Item No. **Report of the Head of Planning, Transportation and Regeneration**

Address SILVER BIRCHES TILE KILN LANE HAREFIELD

Development: Variation of Condition 2 (Approved Plans) of planning permission ref. 75438/APP/2021/1439 dated 6th August 2021 (Erection of a detached 5 bed dwelling with associated parking and amenity space including demolition of existing dwelling). Amendments sought to positioning of and reduction in width of the dwelling, dimensions of the garage and rebuilding of garden walls

LBH Ref Nos: **75438/APP/2021/3910**

SITE LAYOUT PLAN - SCALE 1:250

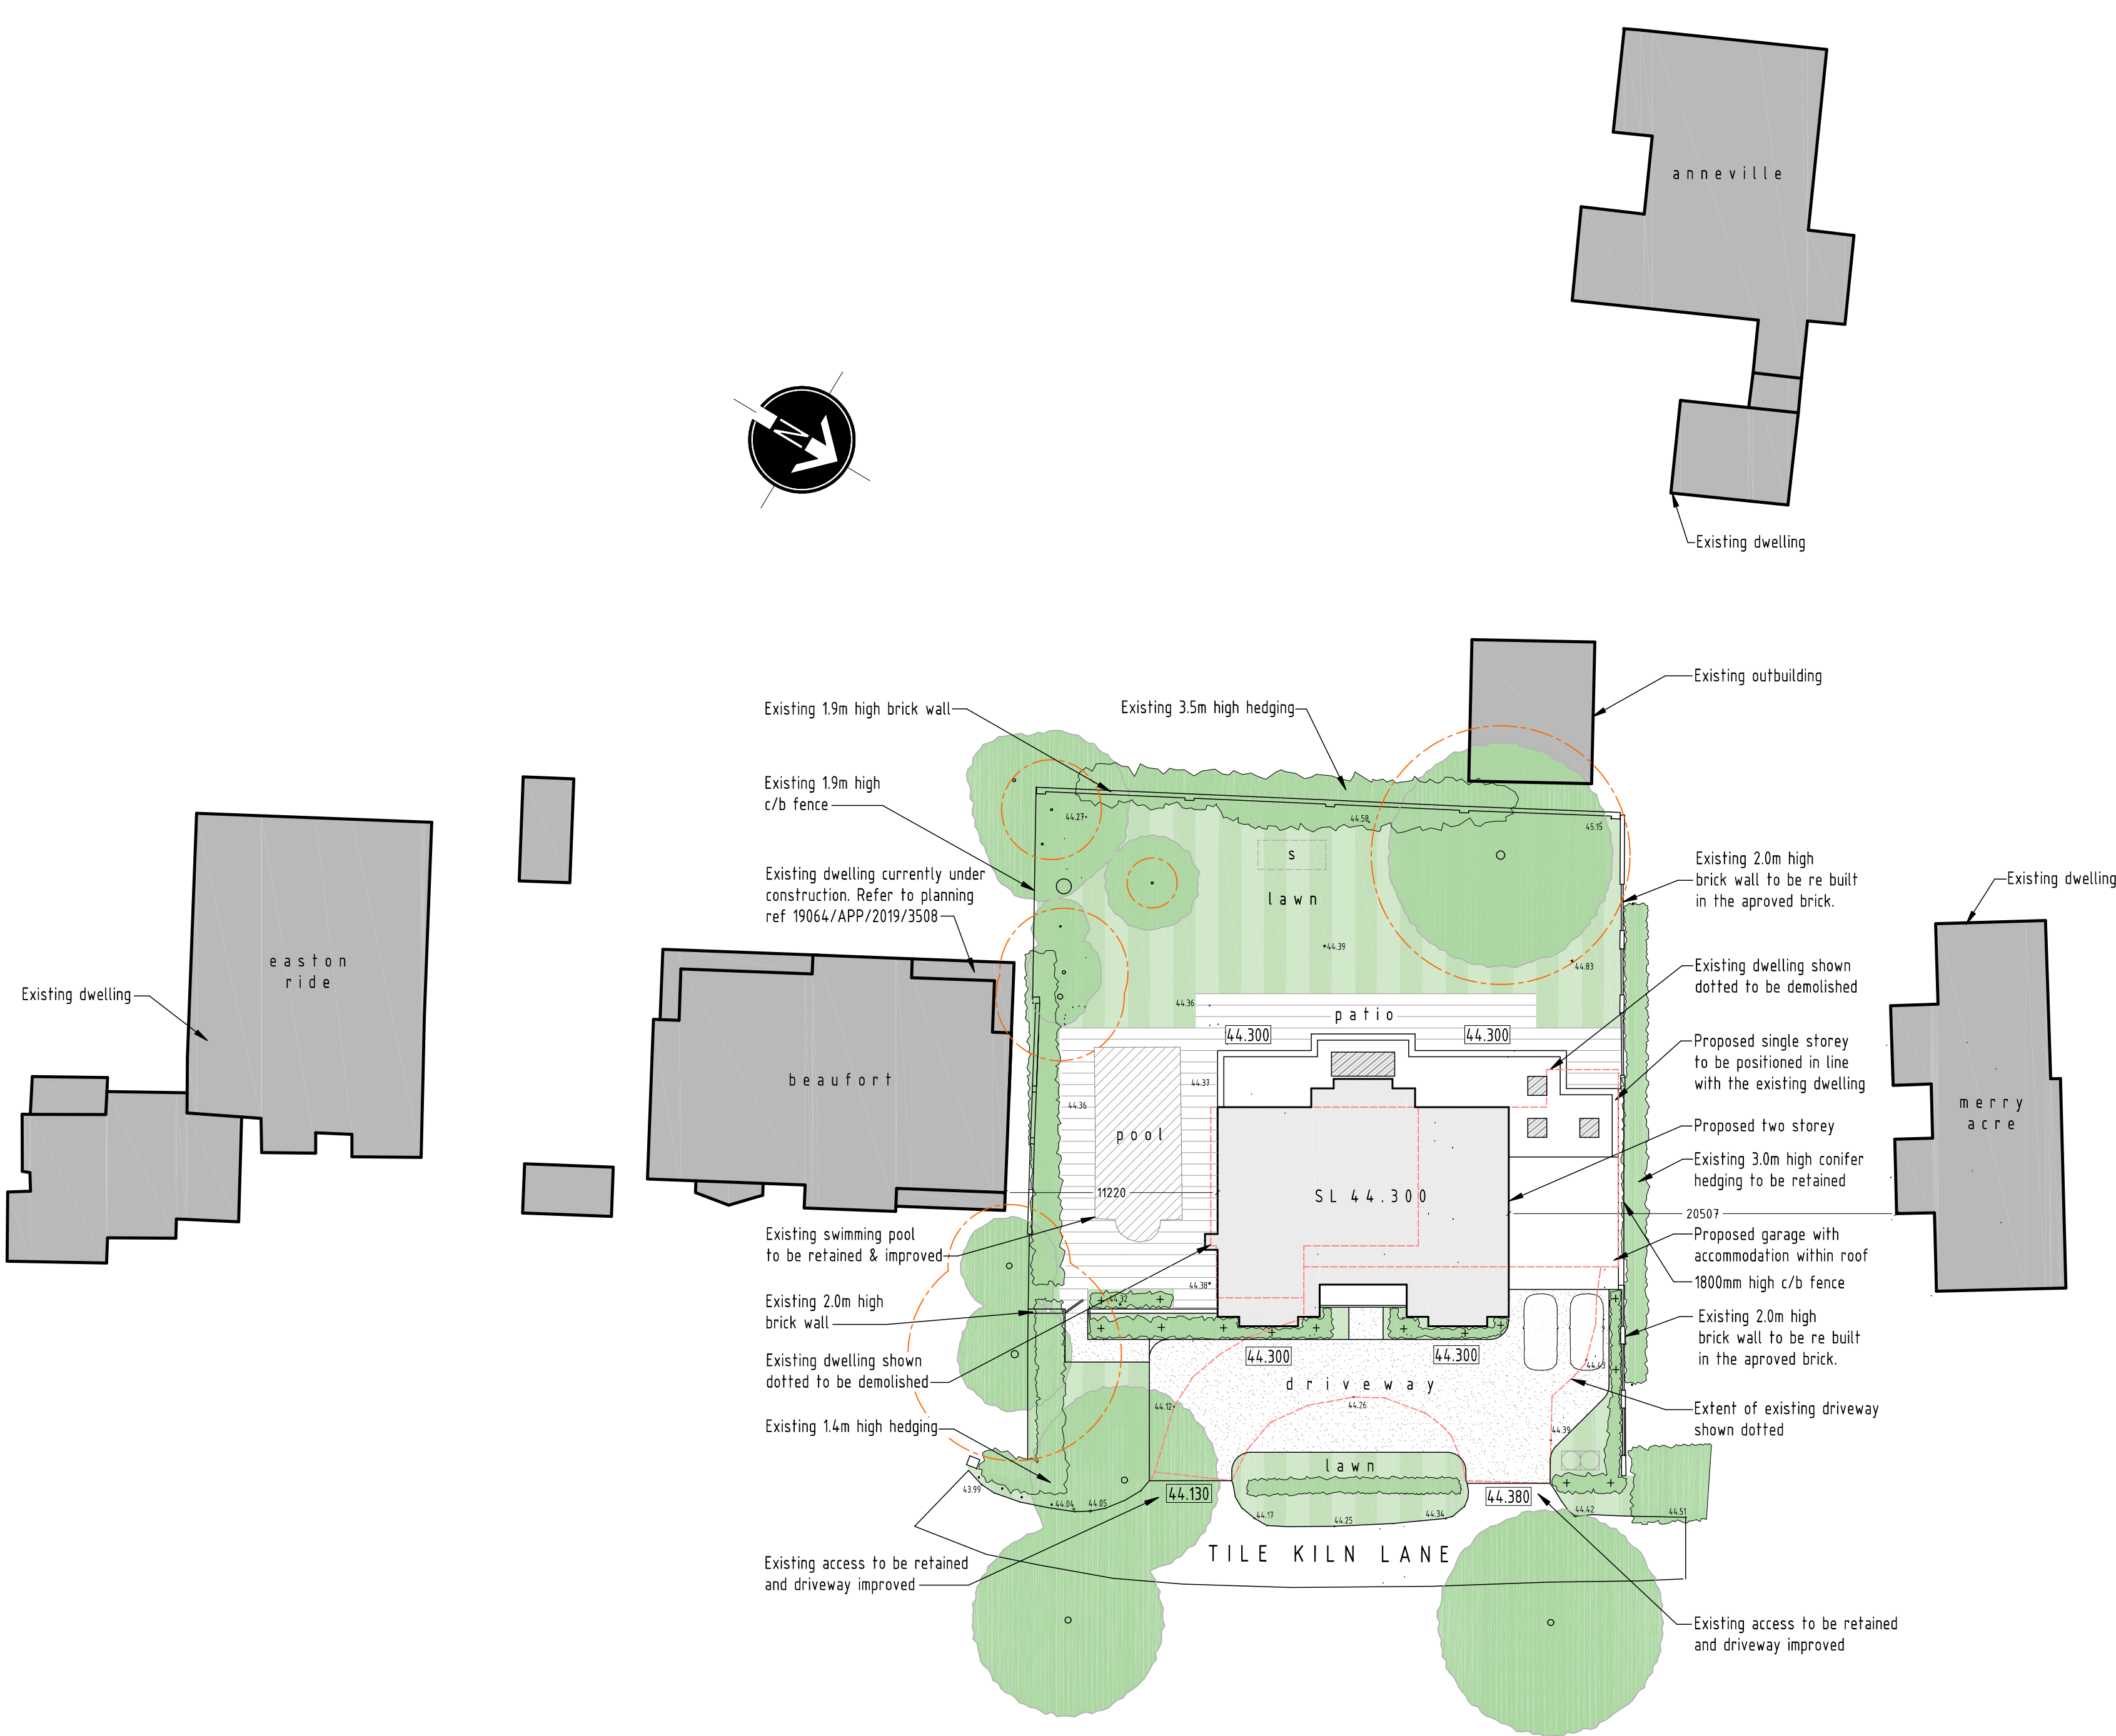
RESPONSE: It is noted that there was a minor discrepancy between the set-back distance of the garage shown on the proposed site plan and proposed floor plans. However, this matter has now been resolved by the applicant, and the proposed site plan has now been updated so that the garage is set-back the same distance as that shown on the proposed plans. Material considerations will be covered in the following sections of this report. The dispute about boundary treatment ownership is not a planning consideration.

rev:	date:	description:	5625 sq.ft
scale:	1 : 100	A1	date: 04 / 10 / 2021
drawing no:	1334 / P2 / VOC / 2	drawn:	FJ
drawing:	PLANNING PROPOSALS FLOOR PLANS		
project:	LAND AT SILVER BIRCHES, TILE KILN LANE, HAREFIELD, UB9 6LU		
client:	MR P. WILLMOTT

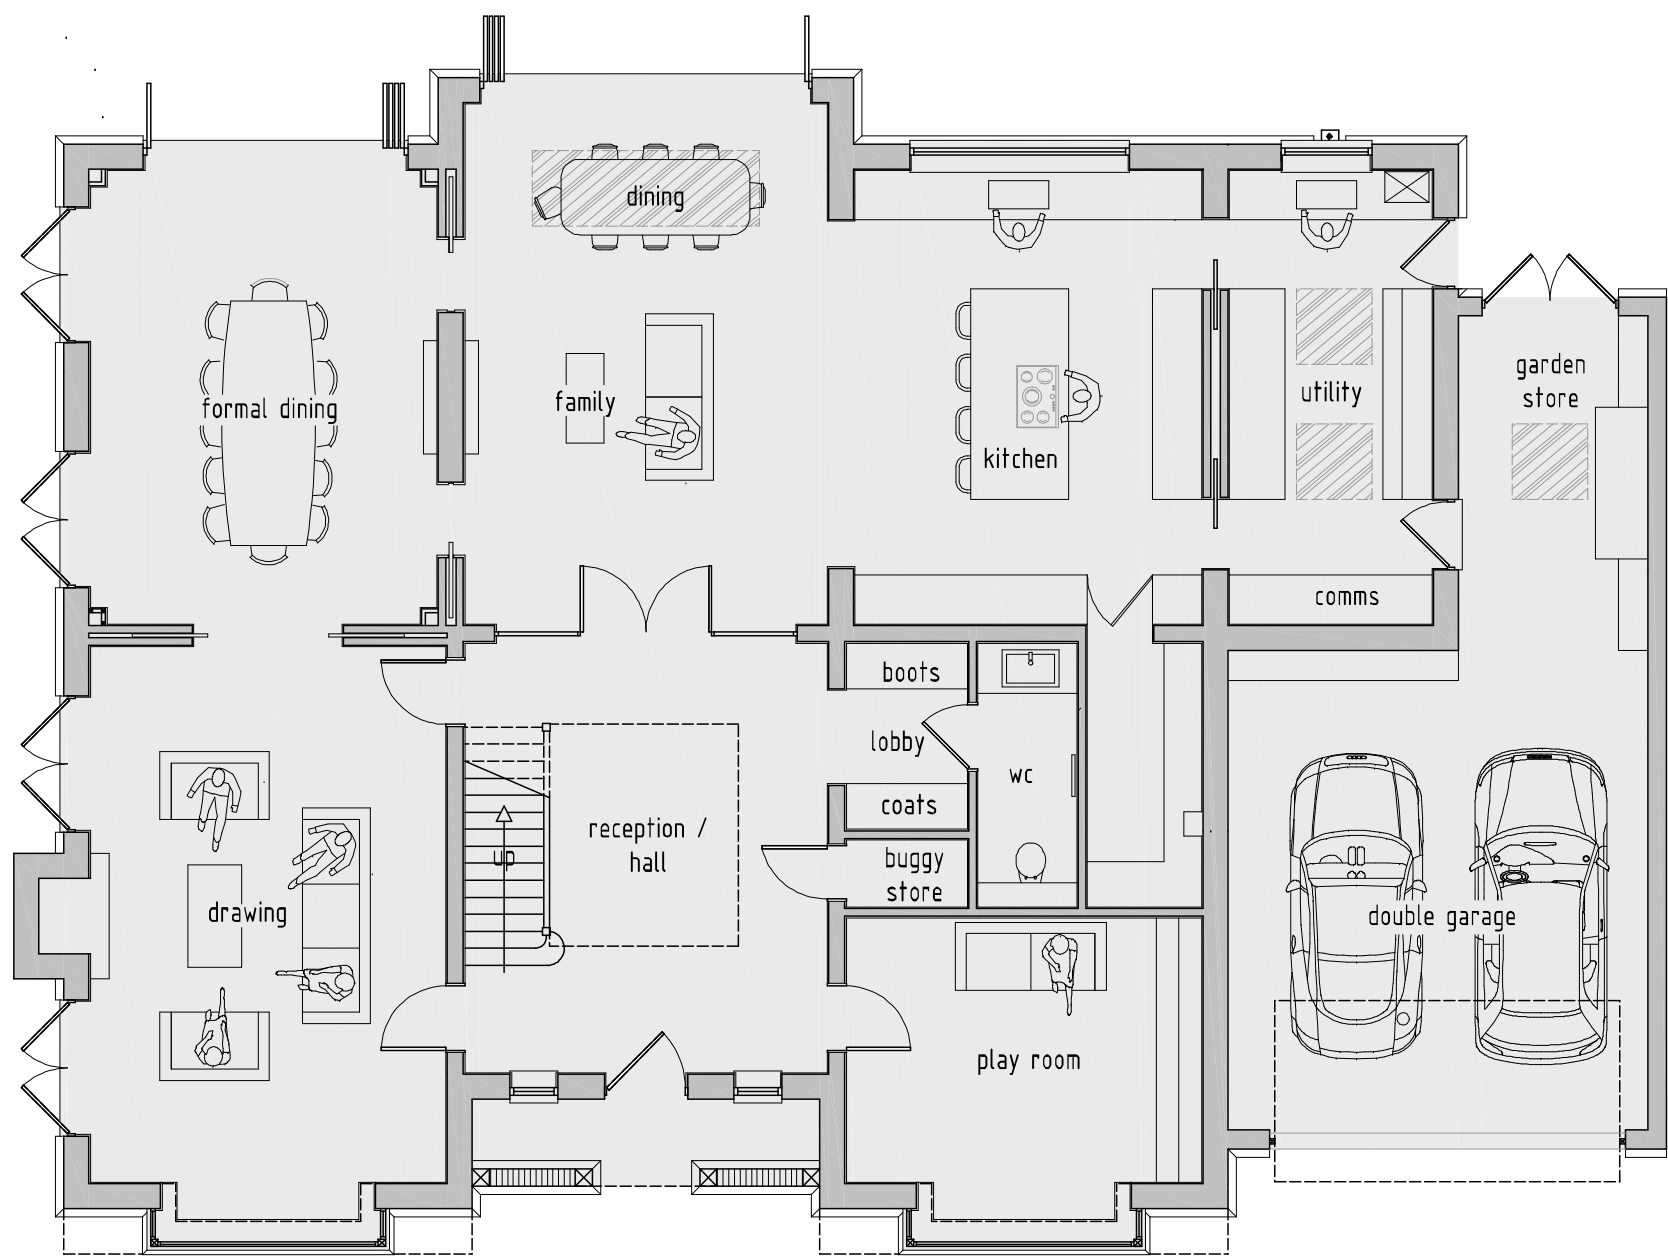
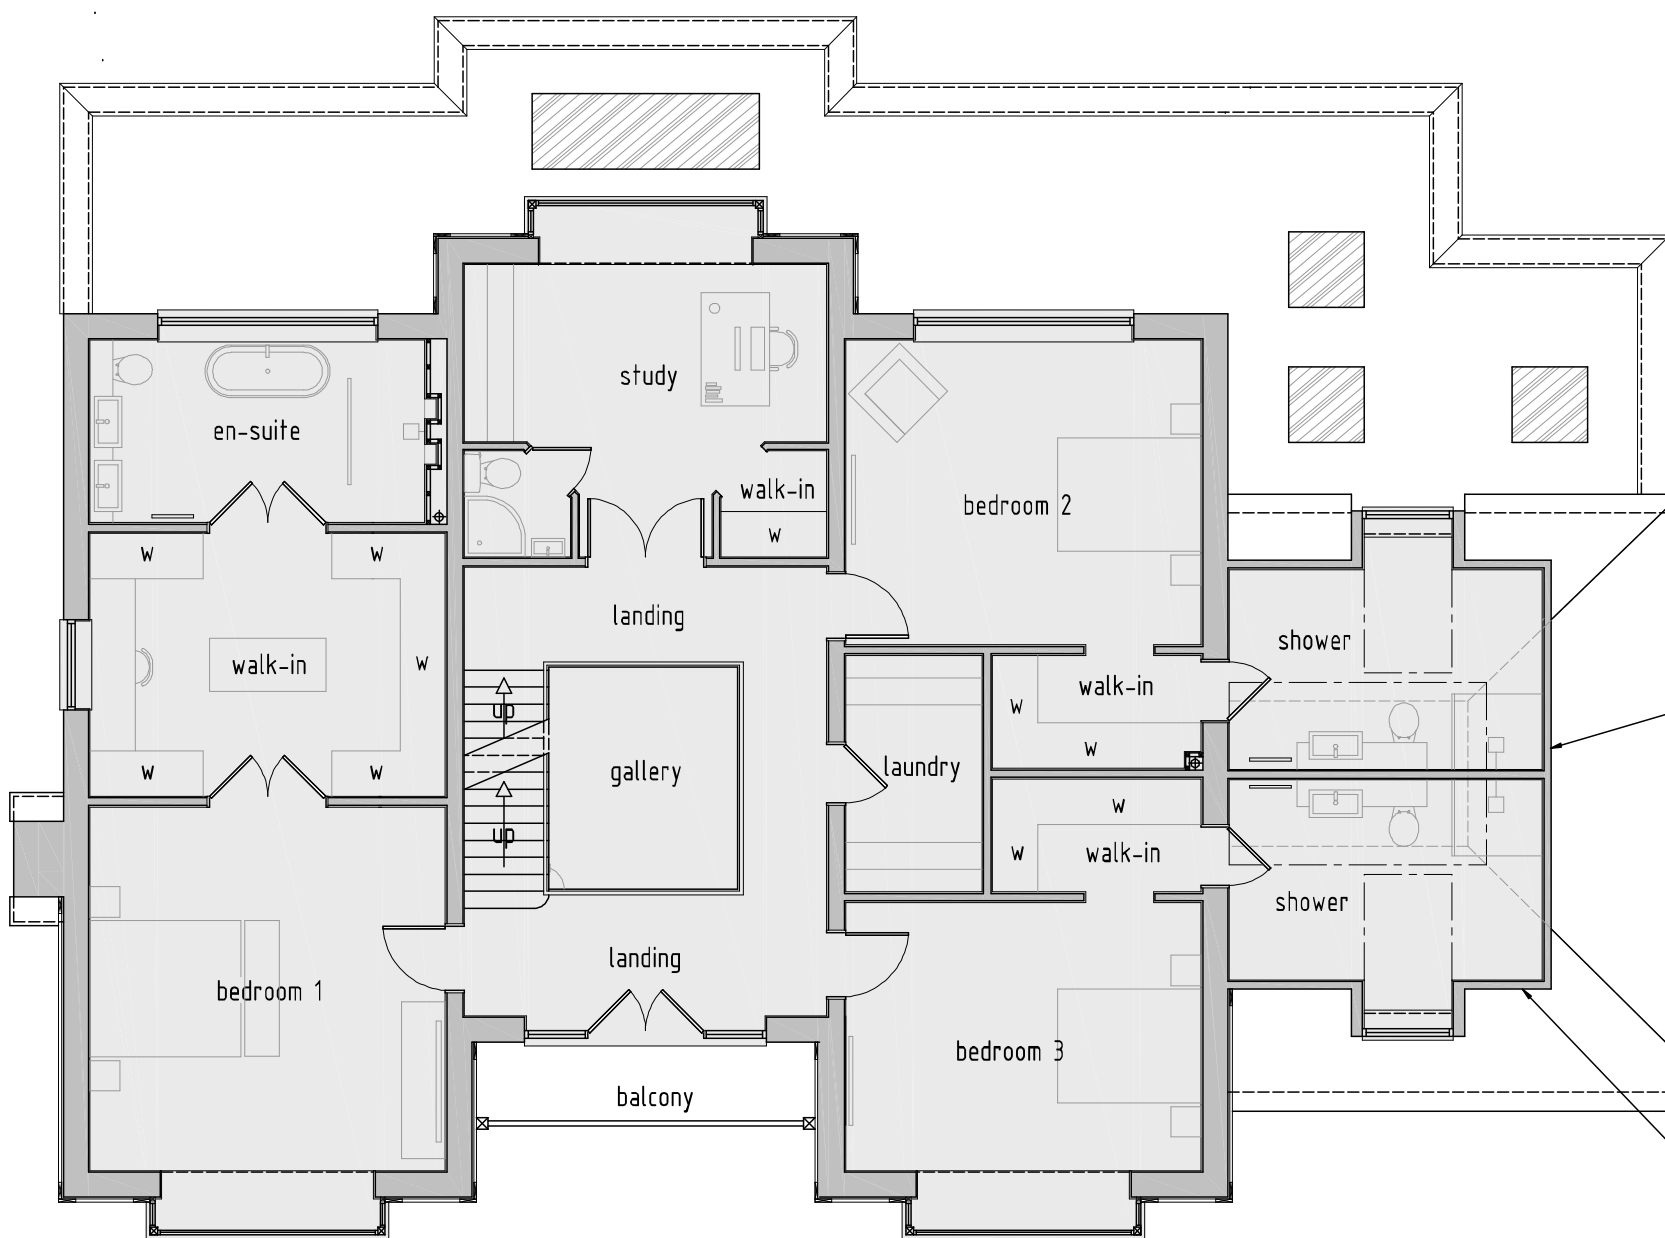
The first floor windows serving the rooms labelled as 'walk-in', 'en-suite' and 'shower' as detailed on approved drawing number 1334/P2/VOC/2 shall be glazed with permanently obscured glass to at least scale 4 on the Pilkington scale and be non-opening below a height of 1.8 metres taken from internal finished floor level for so long as the development remains in existence.
